Building Permit York St

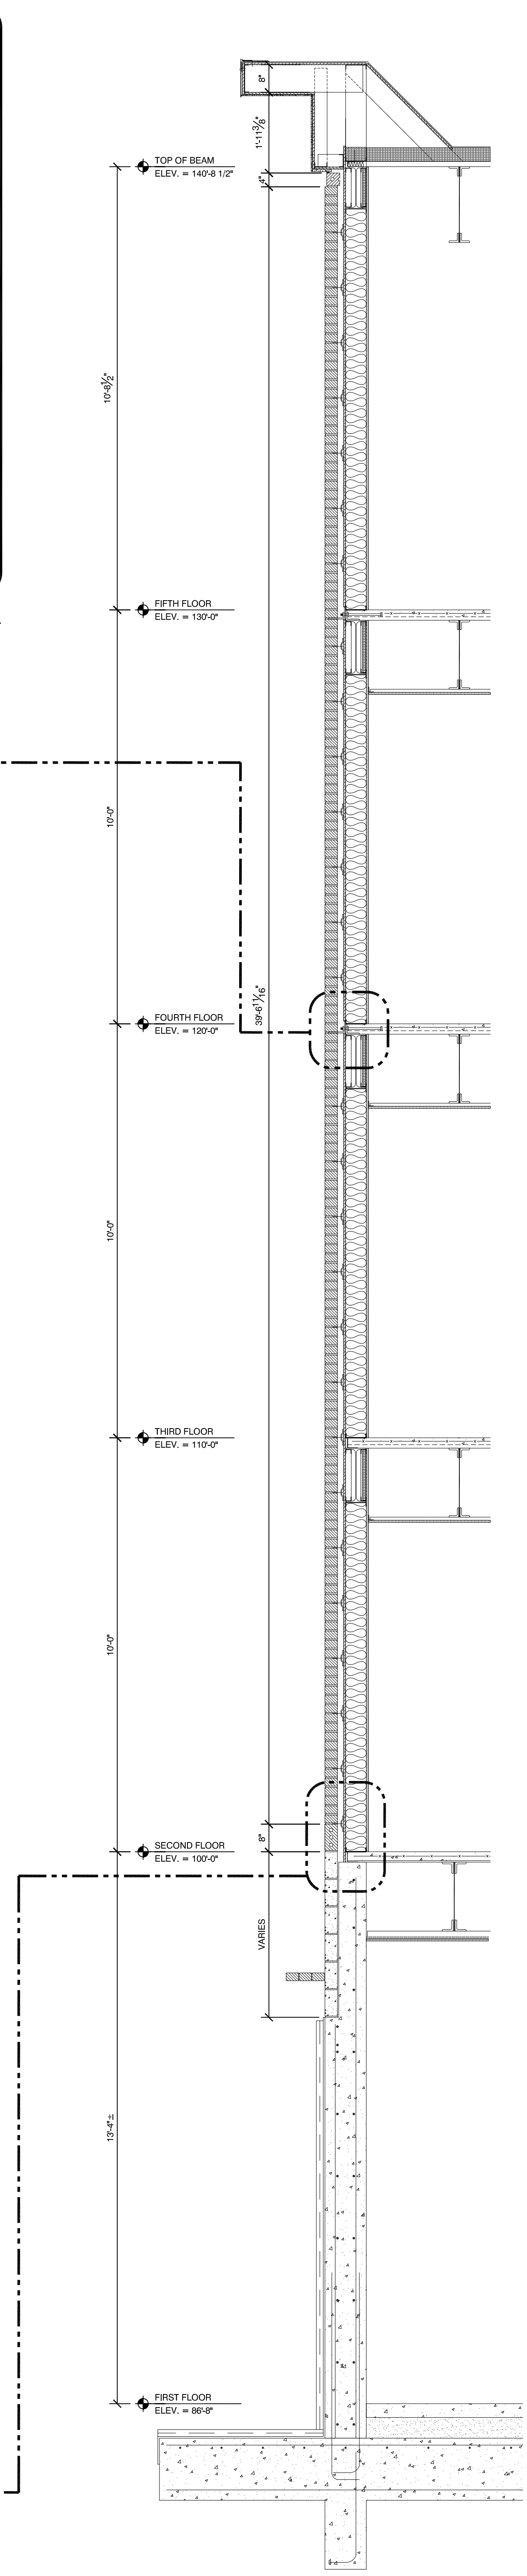
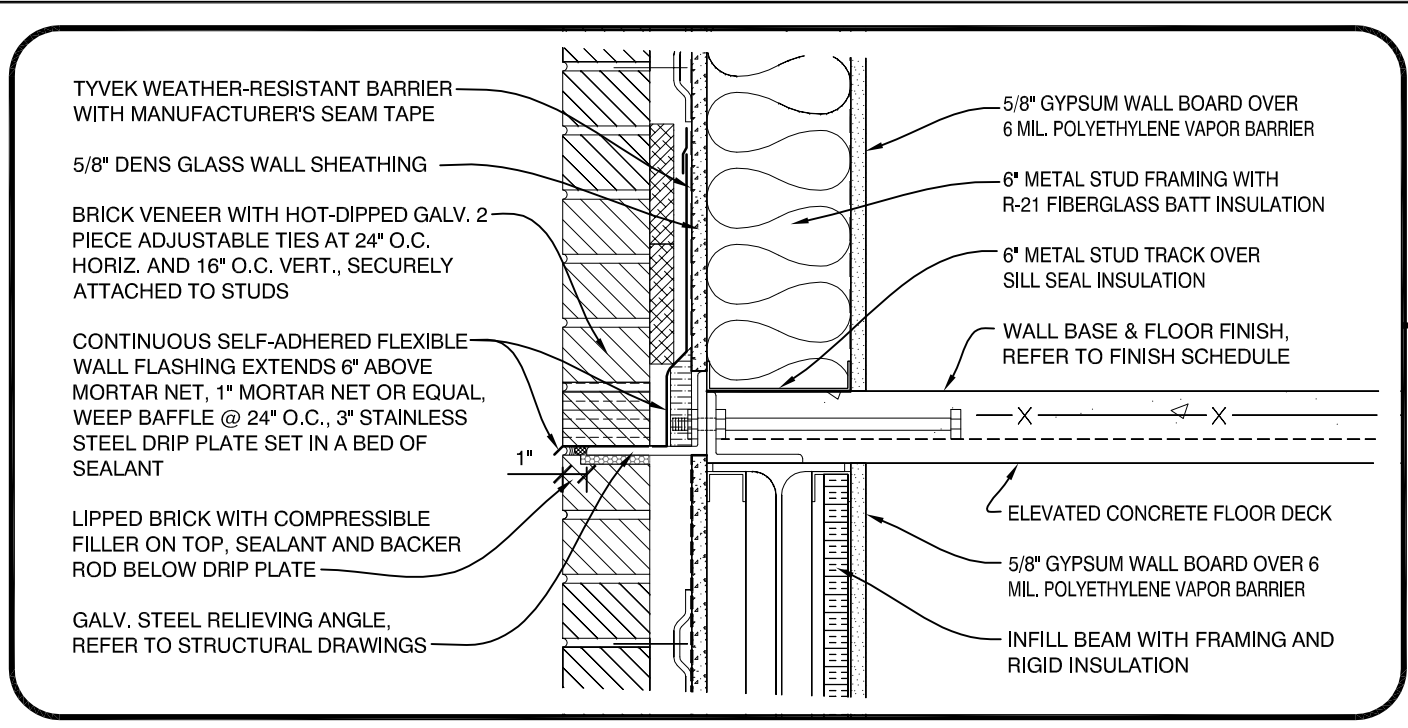
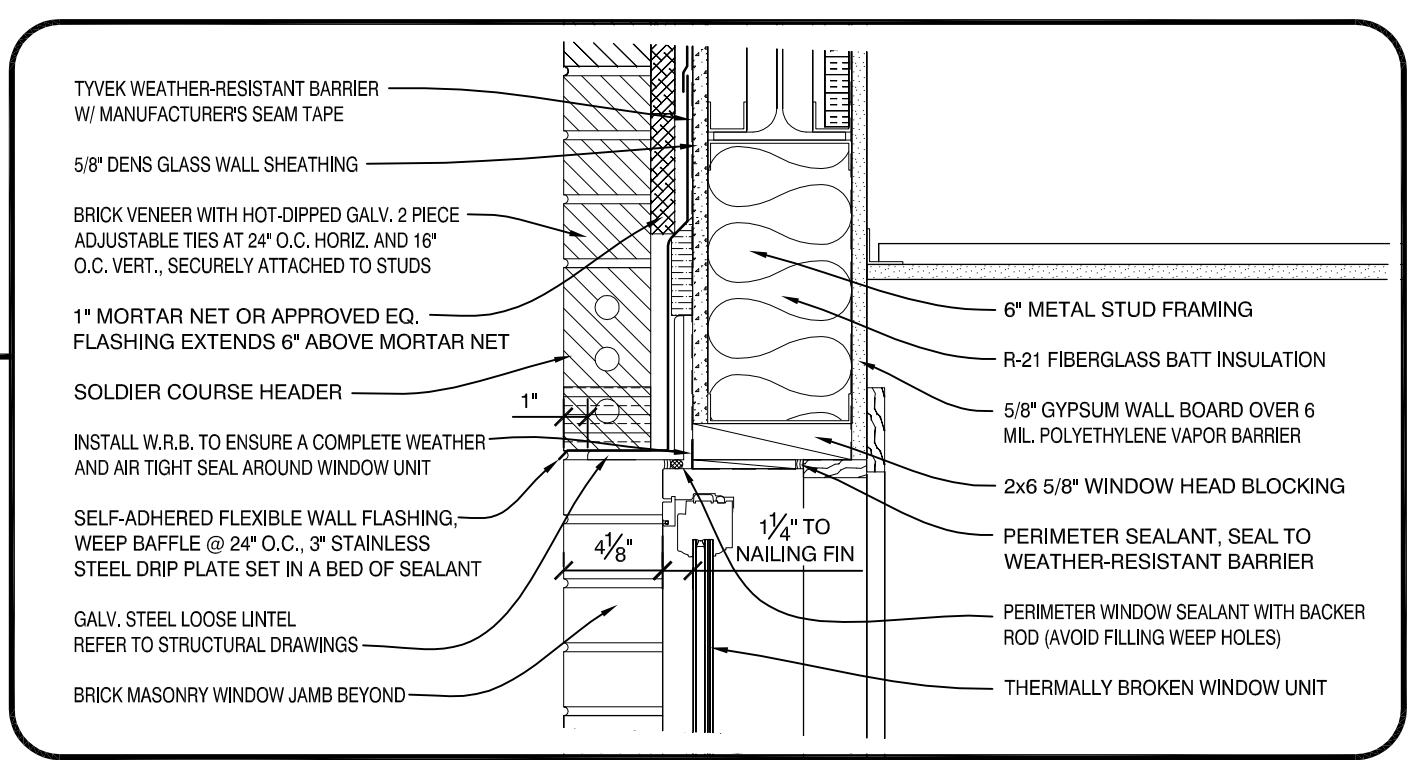
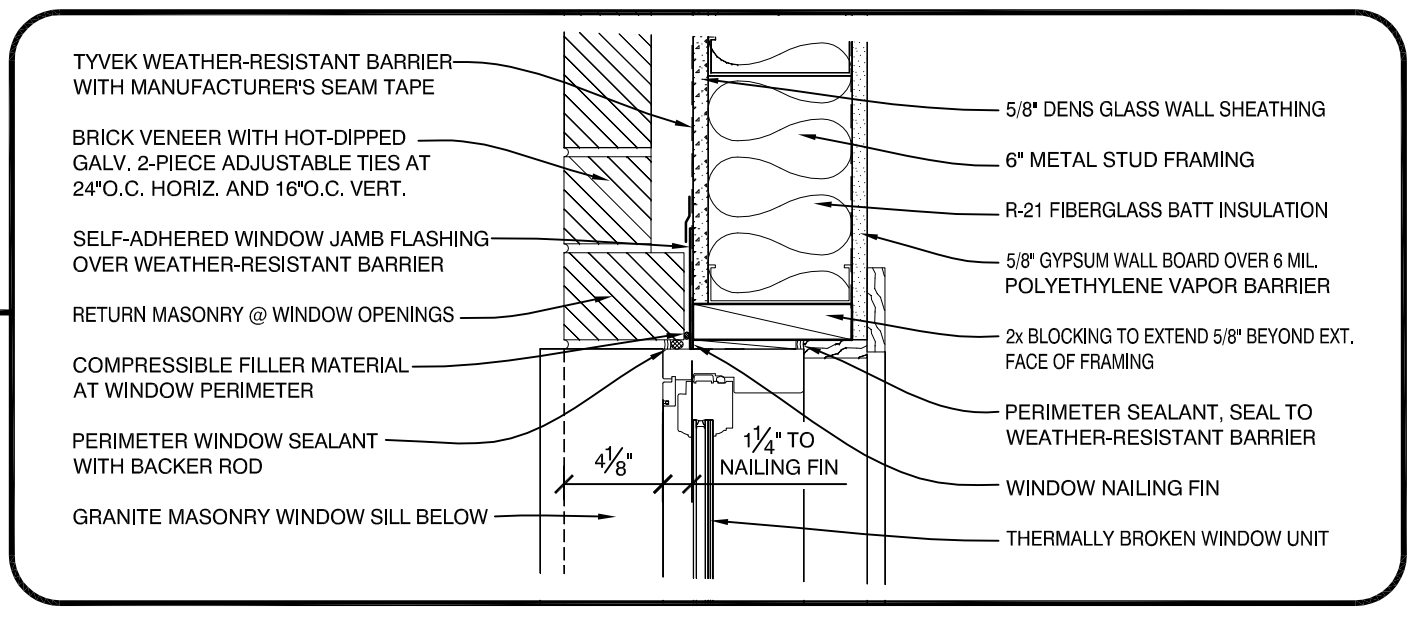
- Attached are the State Fire Marshall permits
- Fire rated construction required at overhangs along North and West sides of building. Details have been updated on sheets A4.01, A4.12 and A4.13

sheet number:
LS1.01

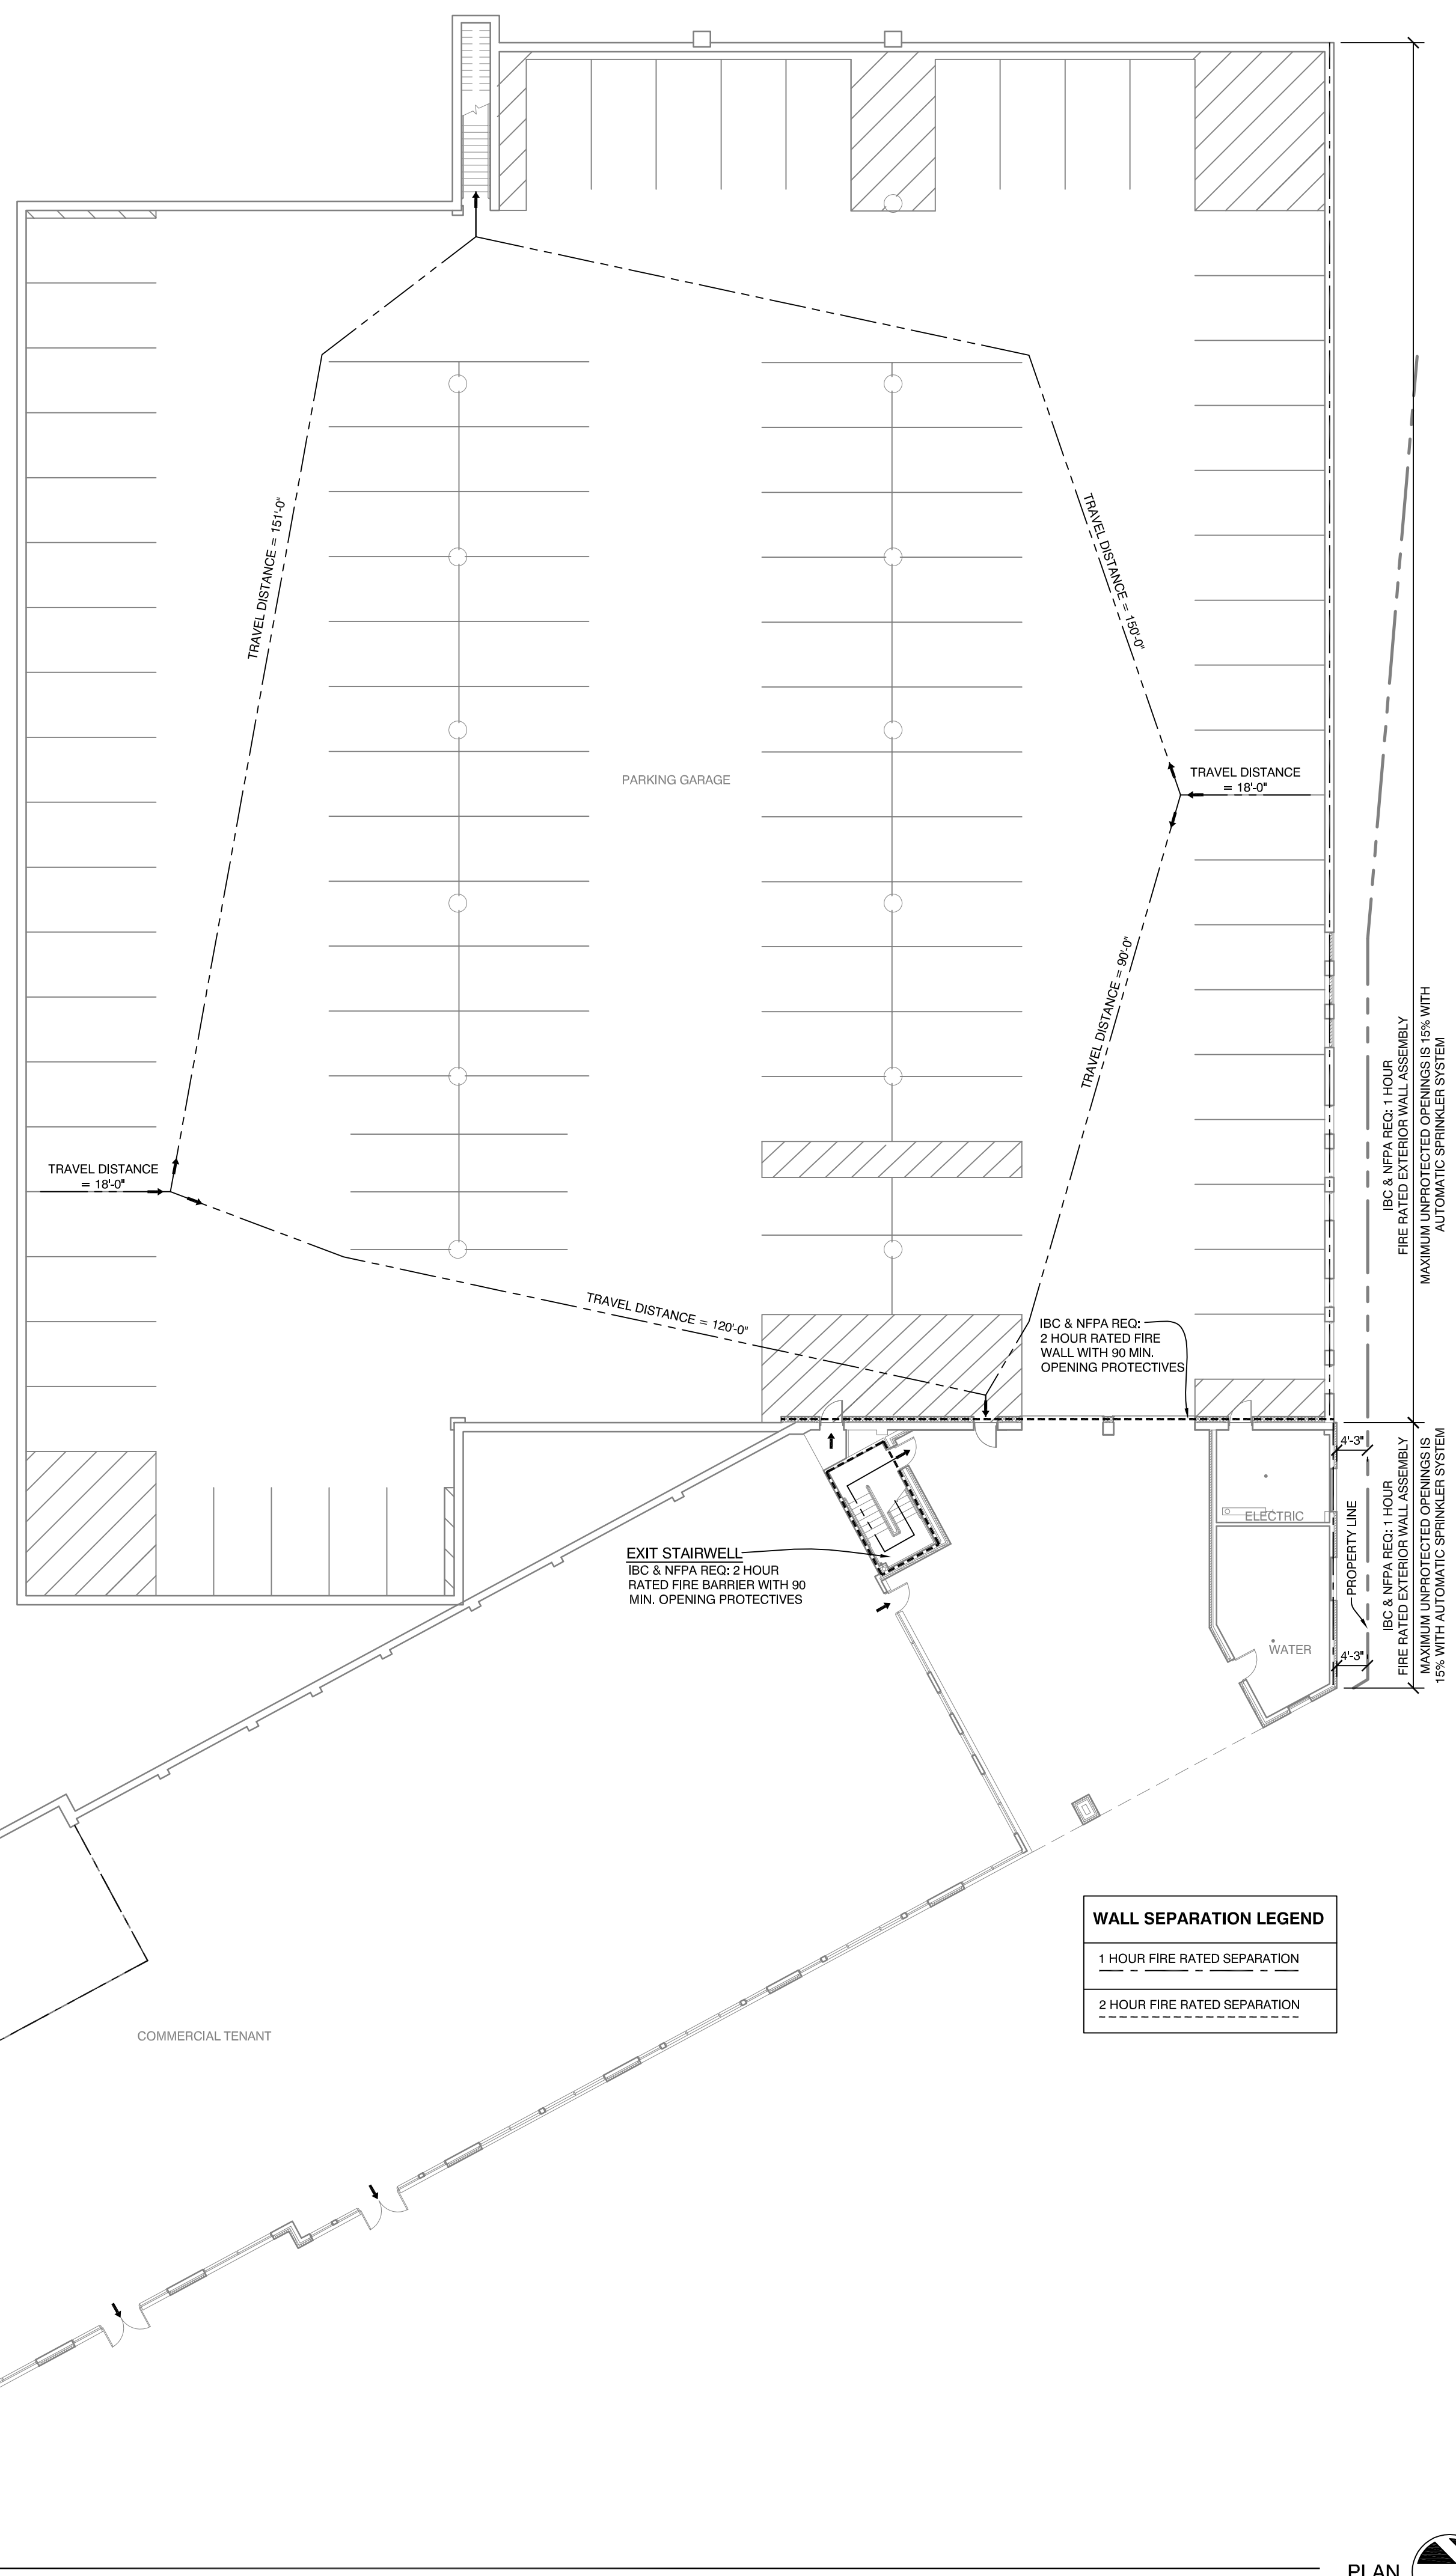
- Maine Human Rights ANSI ICC A117.1 for Type B units other than ADAAG required. Reference has been added to sheet LS1.01
- Attached are the plumbing plans and HVAC plans. The remainder of MEP plans will be submitted as they are completed.
- Attached please find the Energy Model
- Horizons Engineering has been hired to perform a foundation as-built survey. I will forward the plans once completed.
- Review exits and their locations relative to the public way. "Egress Court" option.
 - The stairwell that exits within the "drive-under" area is "permanently appropriated to the public" and therefore considered a "public way" by ICC definition and thus should satisfy any concerns for its location.
